STATE OF NORTH CAROLINA
DEPARTMENT OF TRANSPORTATION

Addendum No. 1

RE: Contract # C204014

NC-148 (Harvey Parkway) From NC-58 To NC-11

MATCH LINE -L- STA. 189 + 00.00 SEE SHEET UO-7

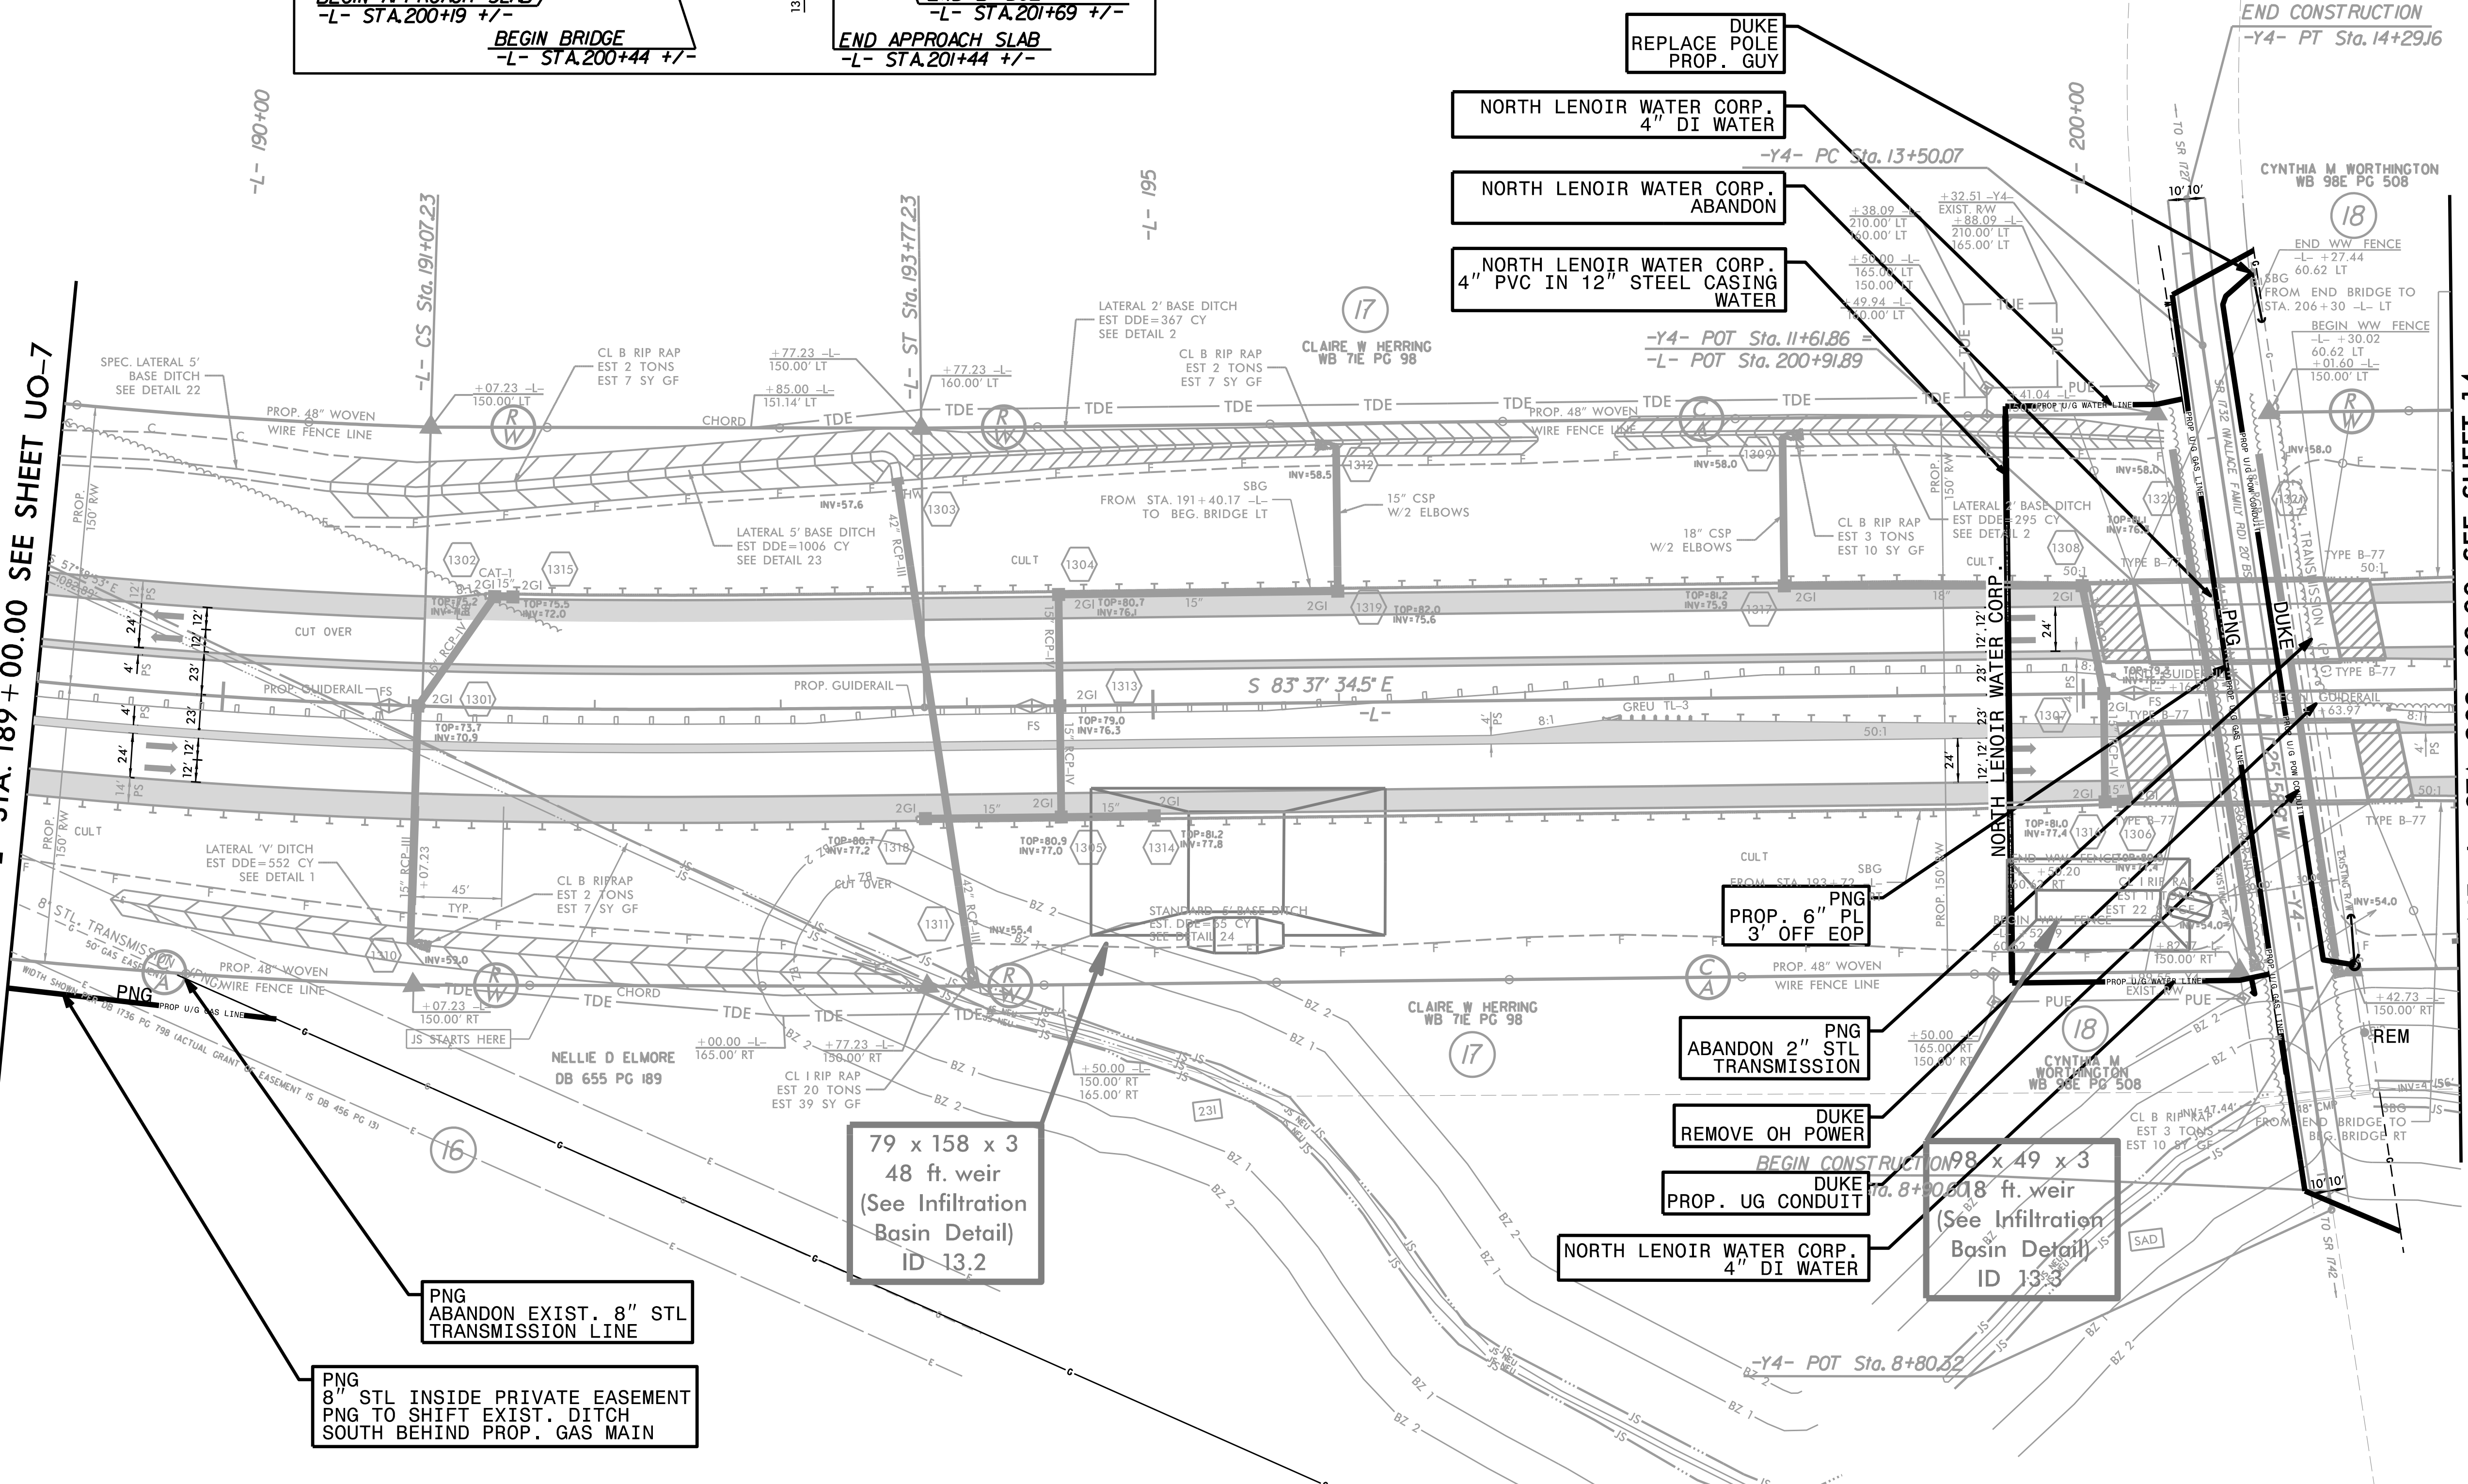
Sheet No.	Revisions
New 2H-1	Added to include "Stockpile Containment Detail"
3D-10 and 3D-11	Revised drainage summary quantities to account for addition of two new driveway pipes
6 and 7	Revised to show 2 new driveway pipe locations
11 and 30	Revised to show areas of possible contaminated soil on Parcels 13 and 48
TMP-1B	Revised to remove the note "D)" concerning hauling restrictions
EC-3A	Revised "Matting For Erosion Control" within the "Soil Stabilization Summary Sheet"
EC-11 and EC-30	Revised to show location of possible contaminated soil
EC-33	Revised to provide correct sheet to show final erosion control for NC58
EC-38 and EC-57	Revised to show location of possible contaminated soil
UO-6	Revised to remove CenturyLink and North Lenoir 8" Water being relocated. These two utilities can remain in place.
UO-8	Revised to add note for Erosion Control contractor to be aware of the basin near the proposed water line
